Your Ref: OWPC19395
Our Ref: R/121/18/PDH 04-06-2018
Please ask for:
Zac Denton

Town and Country Planning Act 1990 (As amended)
Town and Country Planning (General Permitted development) Order 2015 Schedule 2 Part 1
Class A

Notification under extended permitted development rights for a proposed single storey flat roofed extension (to replace former conservatory) extending 5m from the original rear wall of the dwelling house, 3.6m high with an eaves height of 3m
4 Homefield Close Rustington

Thank you for your internet representation made on 25th July 2018 which has been recorded as '**an objection**' with the comments as follows:

4 Hatched Close, Ruggington Proposed Extension AHC/01

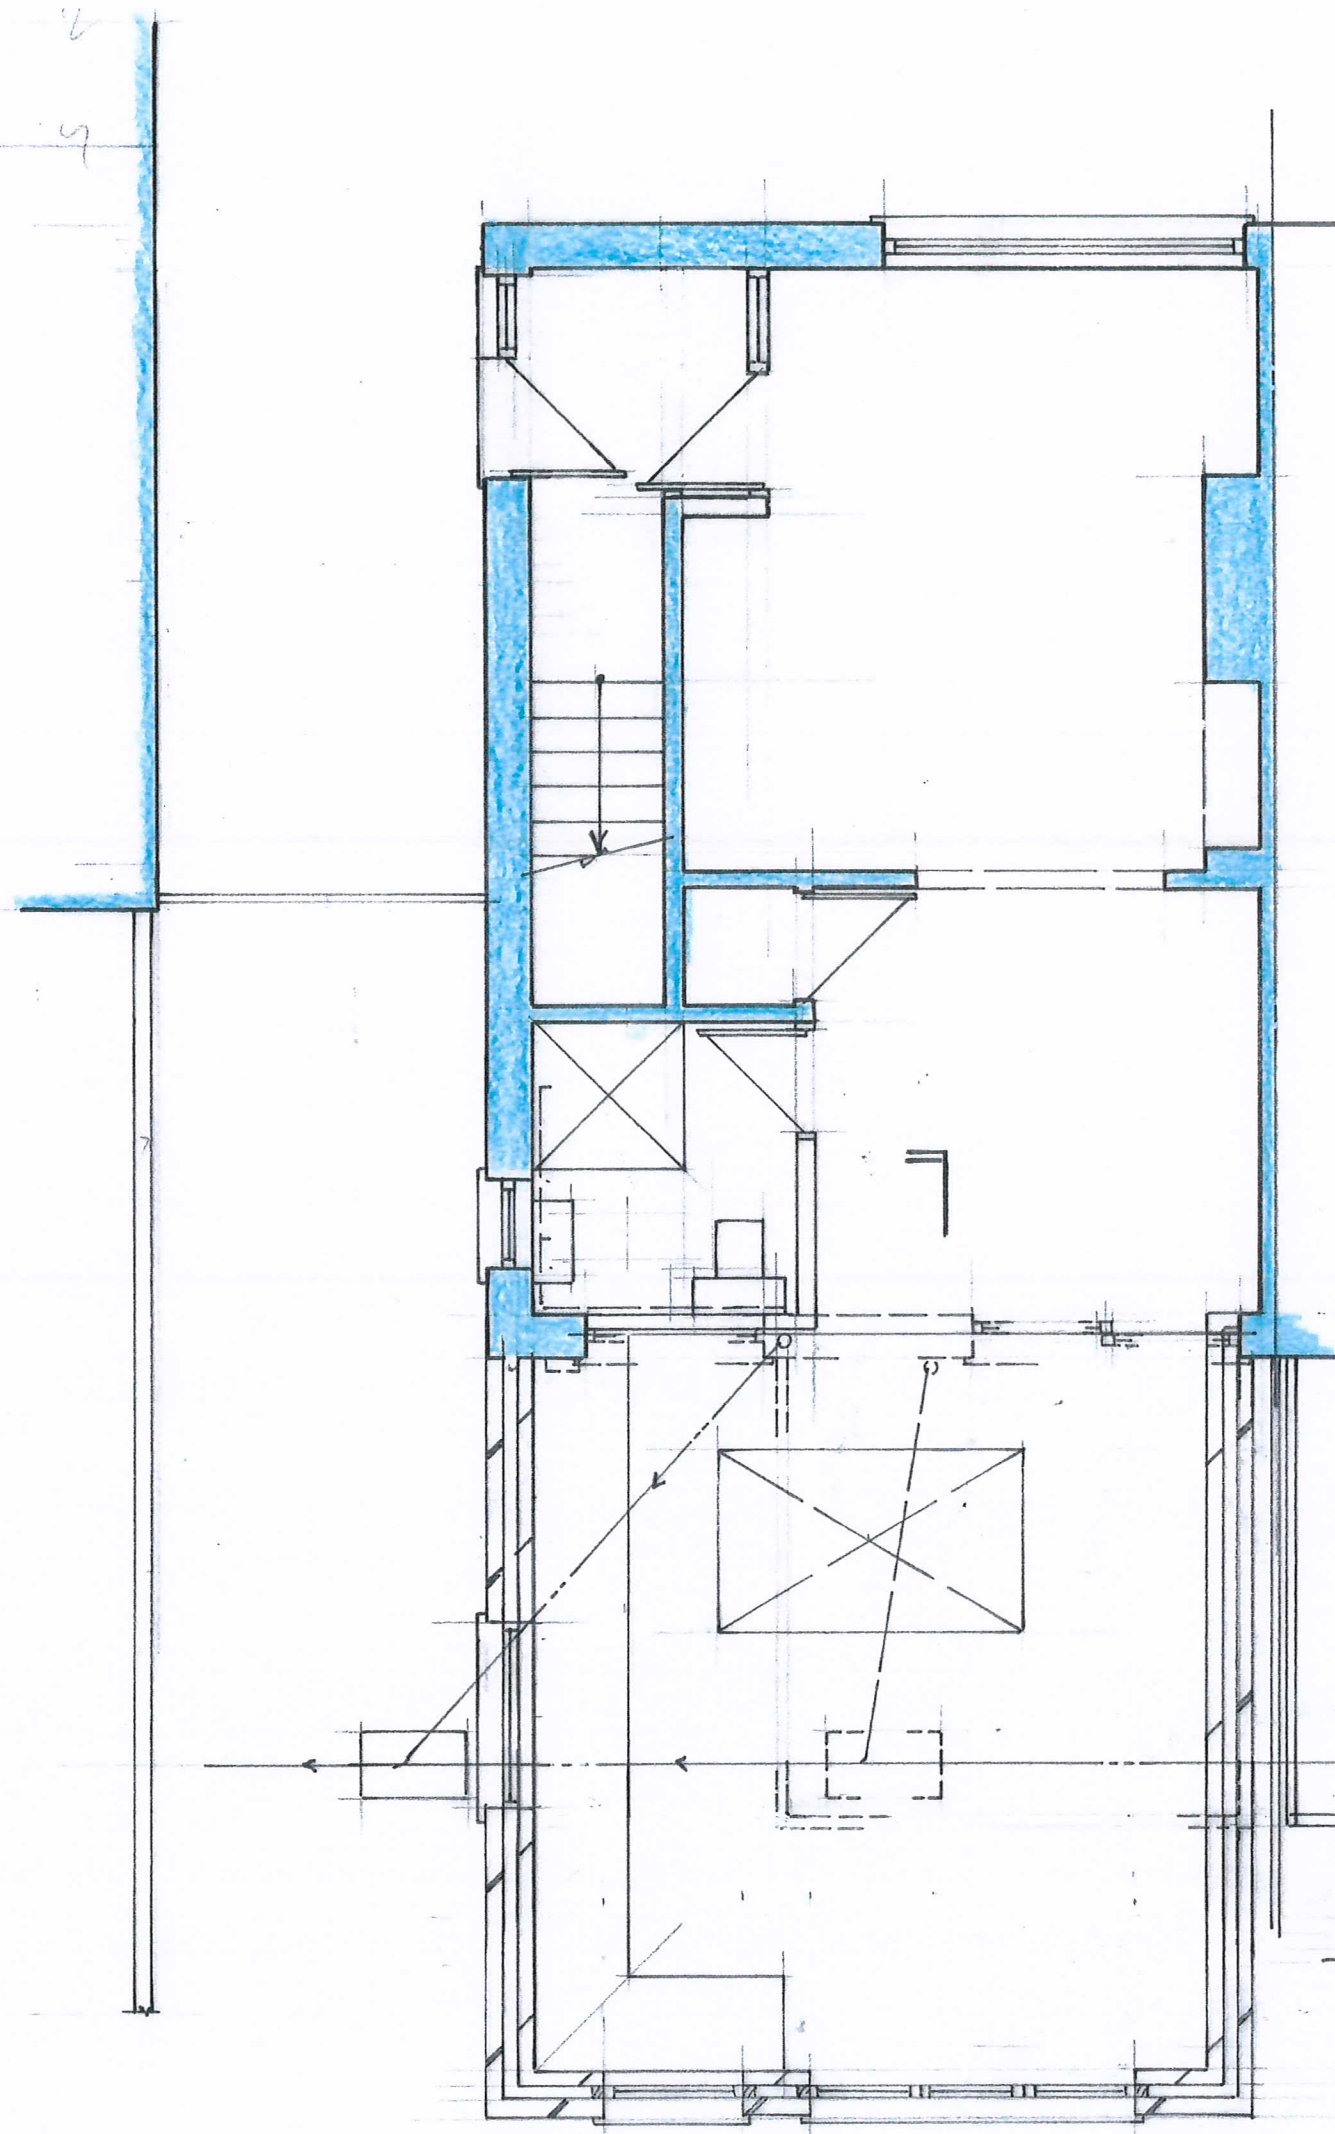
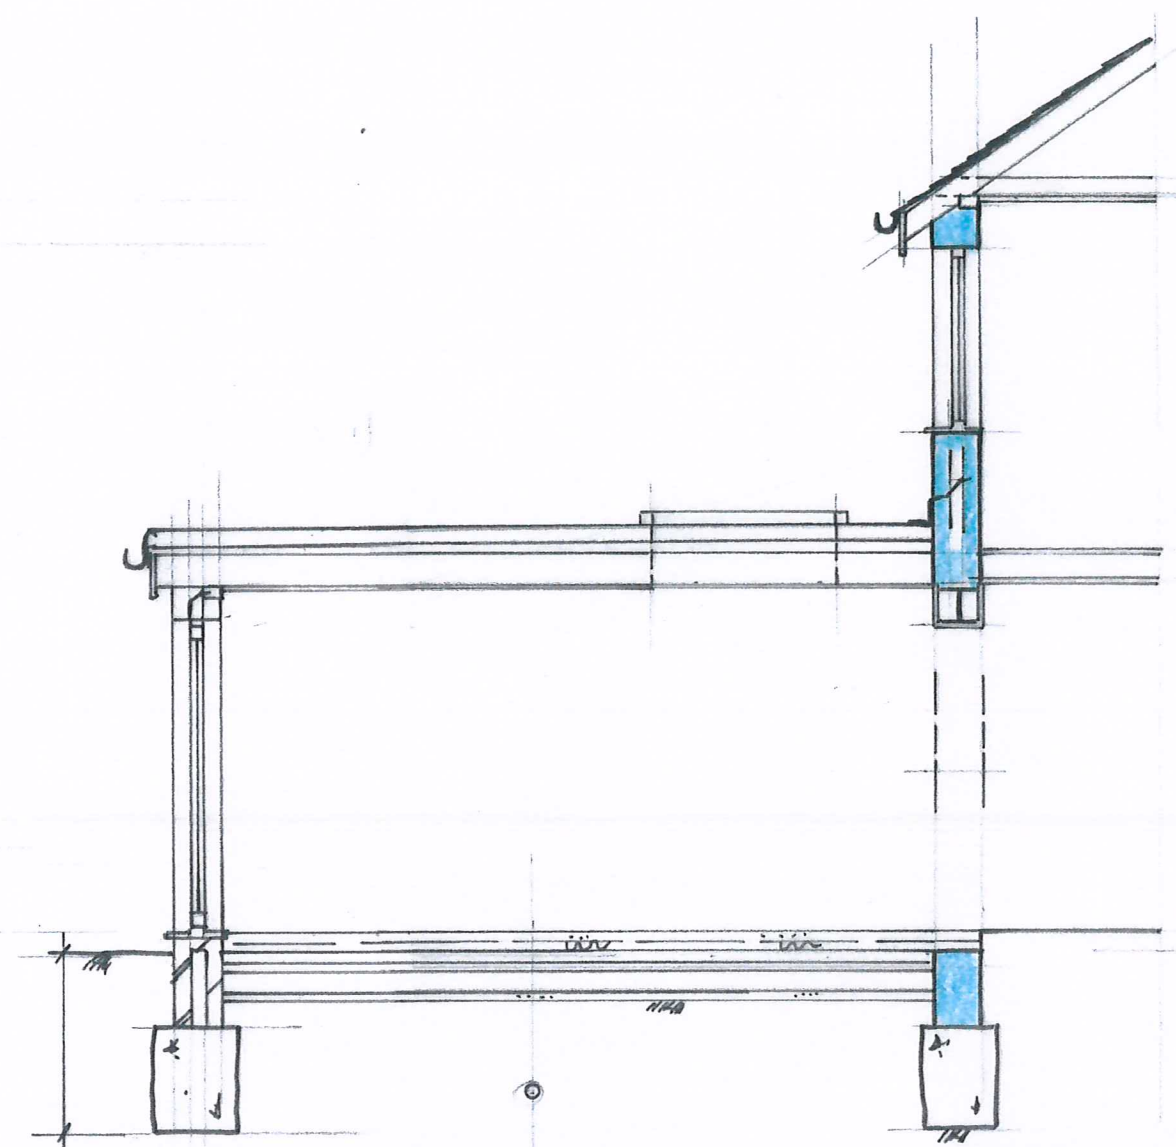
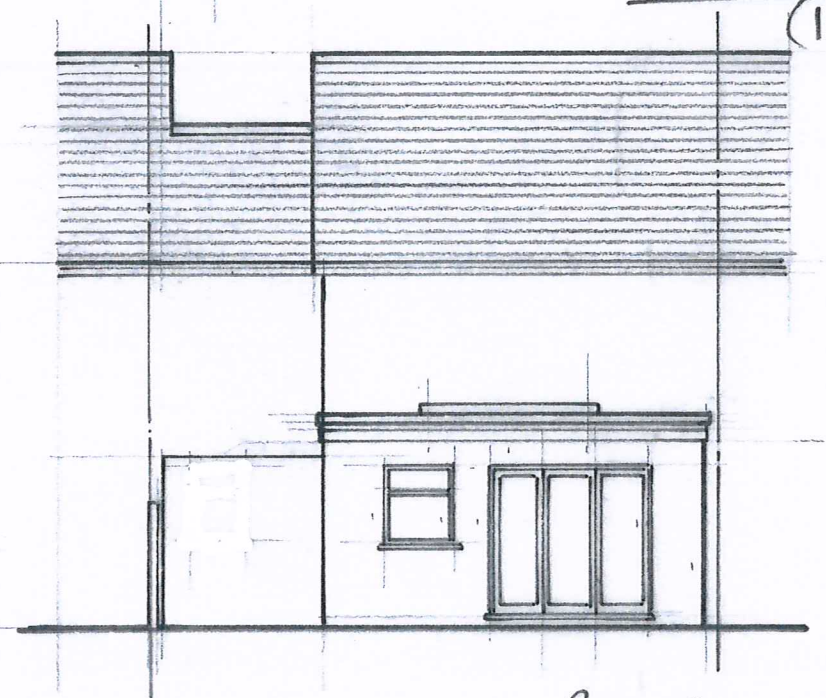
Firstly let Me state that I am in "objection" (at this present time ONLY) given a desire to hopefully glean some additional information from Yourself; as the drawings provided only indicate length and width of the rear extension at 5M (L) X 5M (W).

My main concern given the locality to our rear boundary (running parallel to the proposed extension, S to N); is both the Eaves AND External Height requests (measured externally from ground level), at 3.0M (Eaves) and 3.6M (Overall); respectively.

This to Me appears somewhat of an excessive height for modern day flat roofed extensions; with the more common being (as I have been advised by builders) at a lower eaves/overall height. Such a height at 3.0M runs a real risk of being detrimental to our view, reducing natural light (by casting a rather looming shadow over the entirety of our rear garden); which I am sure would only be compounded even further, when the sun is setting in the West of an evening.

As I understand it the overall height (measured externally from ground level) would be just over 3.0M's, as it is flat roofed and I assume that the insulation is directly on top of the rafters?

But. Should Mr/Mrs Short then decide to amend to say a False Pitch/Conventional Ridged Roof; they would have legal authority to add an additional roof height of 0.6M's; which in turn would only then exacerbate ALL of the above points. This adjustment in roof style (at a later date) has to be taken seriously, on the basis that I have no doubt that a 25M squared flat roof, just over 3.0M's from ground level; will very much be considered a safe haven for mating Seagulls and their Young, on an annual yearly basis.
